Recommendation Report for Works to Tree(s) on trees subject to a Tree Preservation Order (TPO)

REF NO: M/111/18/T

LOCATION: Hadley Close
Middleton on Sea
PO22 6PQPROPOSAL: 1x Holm Oak - Crown lift by 6m, remove deadwood, crown reduction by 2-4m. 1x
Box Elder - Crown lift 5m, remove boundary overhang by 2m, crown reduce by
removing between 1-2m of branch end length to reshape and re-balance the
crown**SITE AND SURROUNDINGS**

PLAN REF. 'MC1'

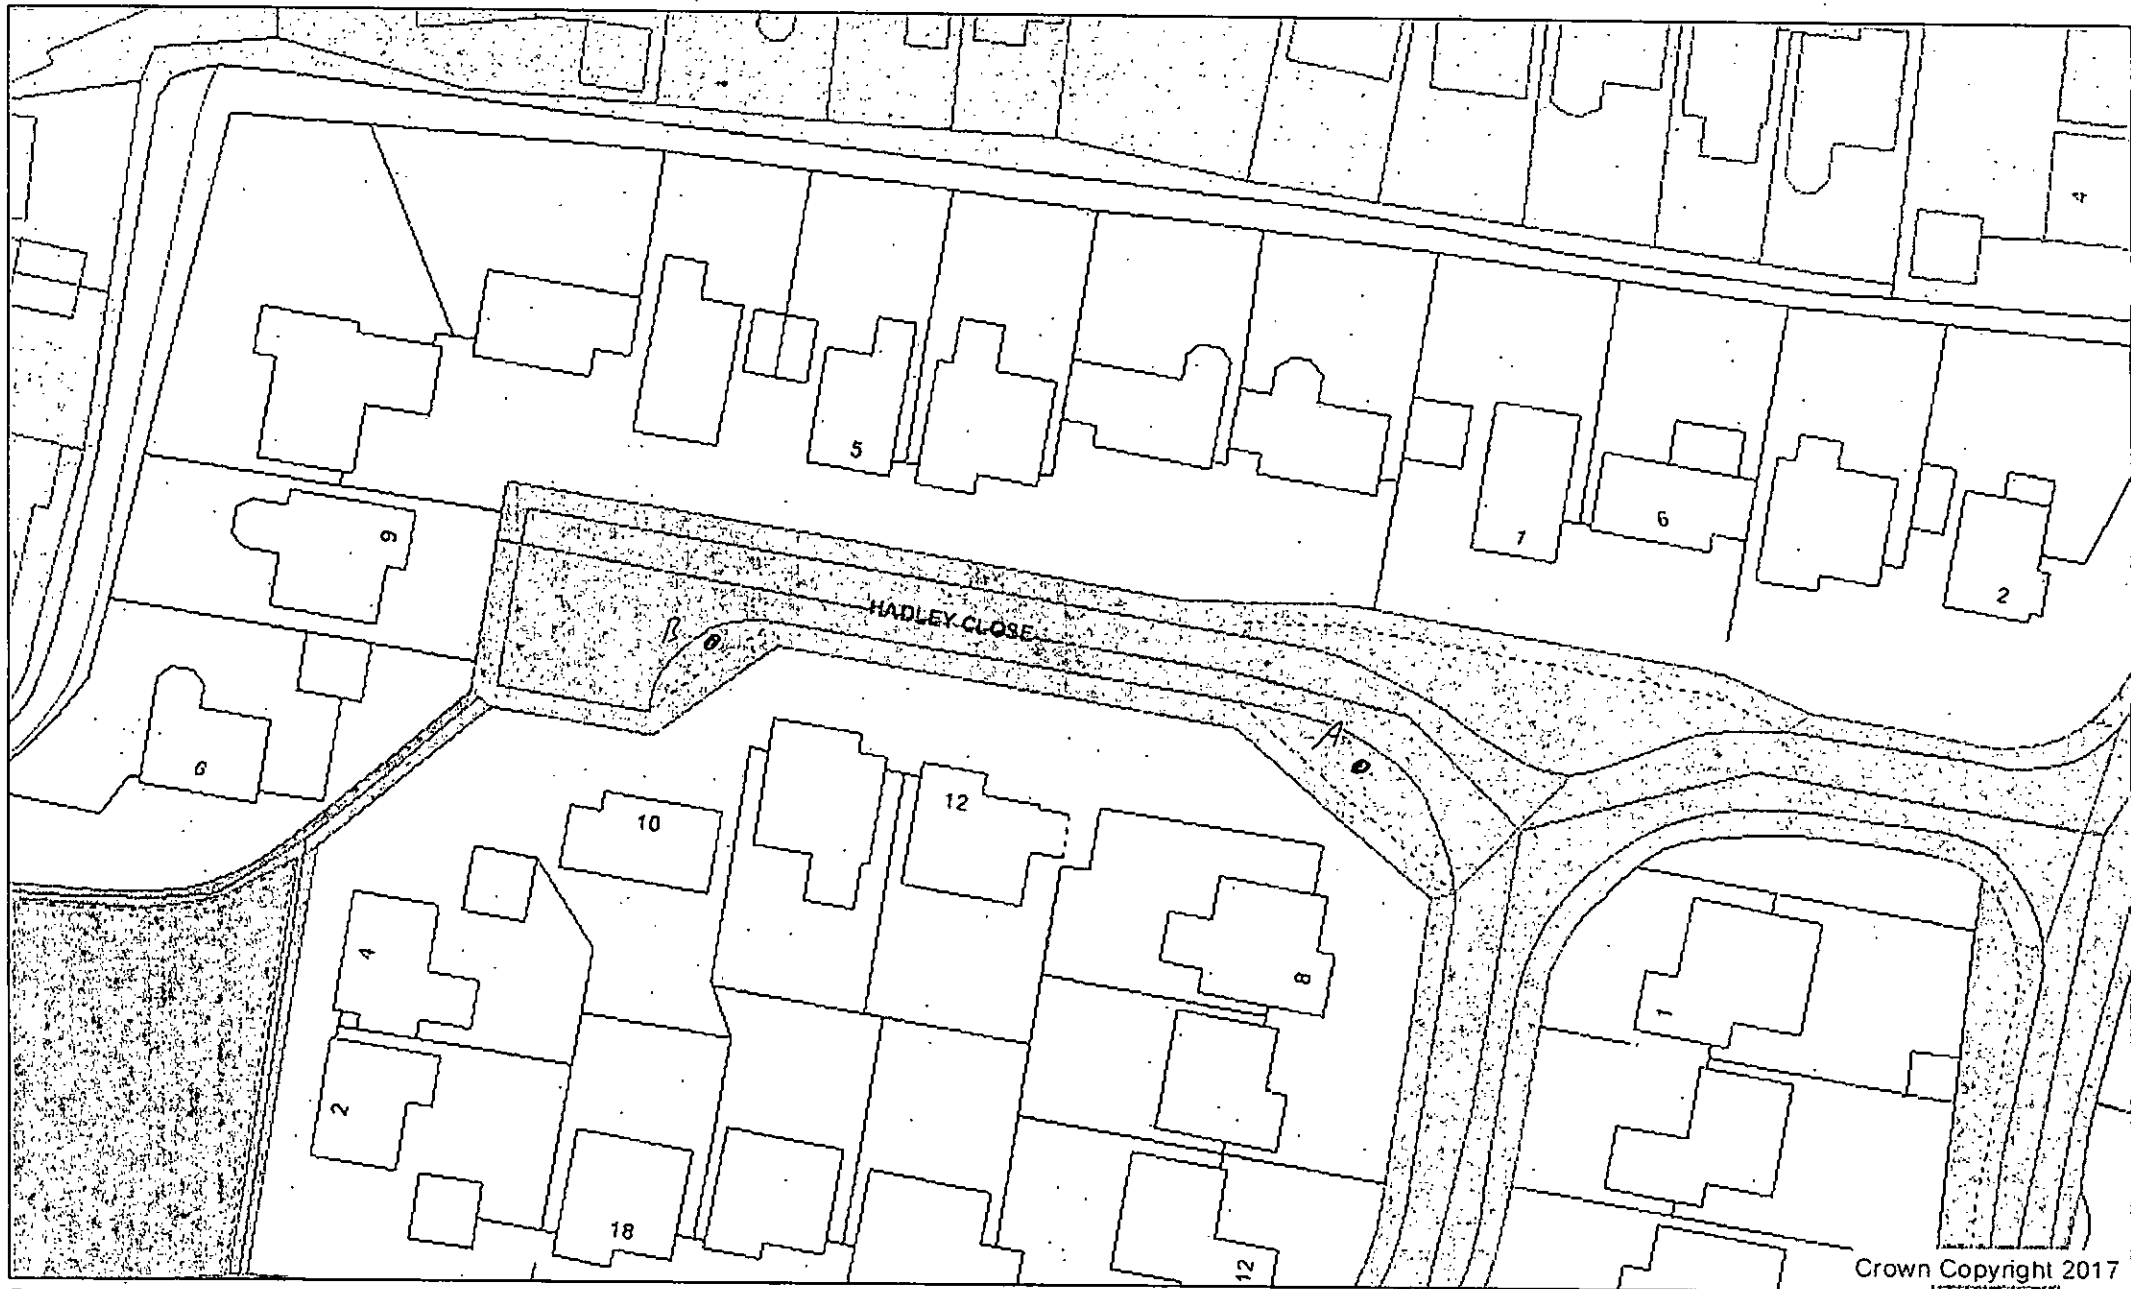
- TA is a large and prominent roadside tree. Its main stem has a number of active and redundant fungal brackets between buttress roots and all around the stem base. An accumulation of recently developed brackets have emerged between the main and subsidiary stem.

- The extent of decay has not been confirmed, although it is; identifiable, established, ongoing and around the stem - so is significant for hazard assessment. The tree is large and occupies a high-risk target area. It has a relatively unmodified crown with established low limbs and branches, although there is some discreet evidence of height reduction on several upper scaffold limbs/branches.

- TB is at the far end of the close in a narrow verge. It has spreading form and not an ideal tree-type for such a confined location. Some form of 'containment pruning' was a foreseeable requirement.

- TA - The work proposed is necessary to mitigate risk of structural failure and so justified on arboricultural grounds. While a temporary loss of aesthetic value is inevitable, satisfactory canopy renewal and recovery should occur if the work is undertaken to a high standard and at an appropriate time of year.

- TB - The work proposed is justified and if undertaken to a high standard will not incur a noteworthy loss of amenity value to the surrounding area.

- Where whole branches are to be removed and final cuts made close to the trunk or branch union they are to be made as shown in Figure 2 of BS3998:2010

- Where branches are to be shortened back the final cuts are to be made at the correct angle shown in BS3998:2010 and adjacent to a live bud or lateral.

- TA - The removal of crown material which has developed since the last operation must be done sympathetically and with respect to established 'knuckles' so as not to extend beyond the point of origin.
